RE: Mr. Rogers Short Plat (SP-08-00023)

The Kittitas County Community Development Services Department has determined that the Mr. Rogers Short Plat (SP-08-00023) is a complete application and hereby grants **conditional preliminary approval** subject to the following conditions:

TO: Trudie Pettit, Community Development Services
FROM: Christina Wollman, Planner II CW
DATE: July 30, 2008
SUBJECT: Mr. Rogers Short Plat SP-80-23

MR. ROGERS ROAD VARIANCE 08-22

**MR. ROGERS SHORT PLAT**  
**PART OF SECTION 31, T. 18 N., R. 19 E., W.M.**  
**KITTITAS COUNTY, WASHINGTON**

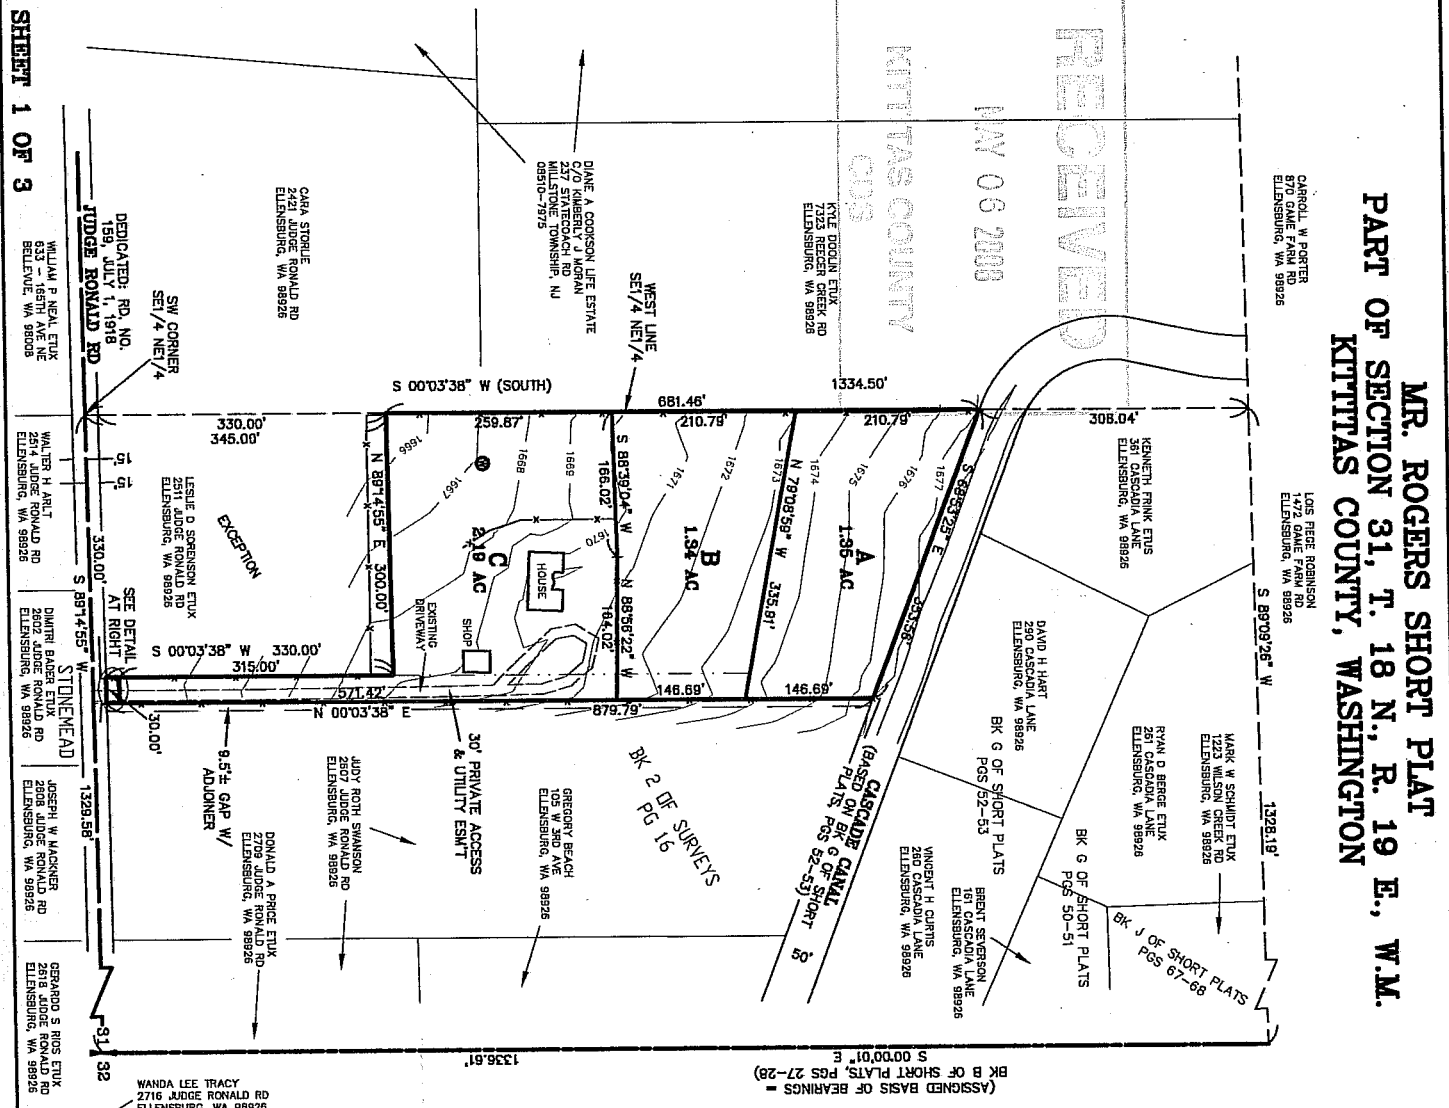
1. Both sheets of the final mylars shall reflect Short Plat number SP-08-00023 and an accurate legal description shall be shown on the face of the final plat.

2. Easement Width: Road Variance 08-22 was approved allowing the applicant to construct the road within a 30' easement instead of the required 40' easement.

3. Private Road Improvements: Access from Judge Ronald Road to the cul-de-sac shall be constructed to meet or exceed the requirements of a High-Density Private Road that serves 3-14 tax parcels. The applicant has received a variance for easement width. See Kittitas County Road Standards, 9/6/05 edition.

4. Cul-de-Sac: A cul-de-sac turn-around having an outside right-of-way easement diameter of at least 110 feet shall be constructed at the closed end of all dead-end roads serving 3 or more lots. The driving surface shall be at least 96 feet in diameter. Cul-de-sacs must also conform to the requirements specified by the 2006 International Fire Code. Contact the Fire Marshal regarding any additional cul-de-sac requirements.

The applicants have applied to short plat property on Judge Ronald Road approximately 1000' west of Wilson Creek Road. The short plat will create 3 lots with an average lot size of 1.62 acres. A 40' easement is required. The subject property is a flag lot with a 30' wide by 330' long stem leading to the county road, which makes a 40' easement impossible without receiving an easement from neighboring property.

Road may be constructed within the 30' easement and shall meet all other requirements of Kittitas County Road Standards.
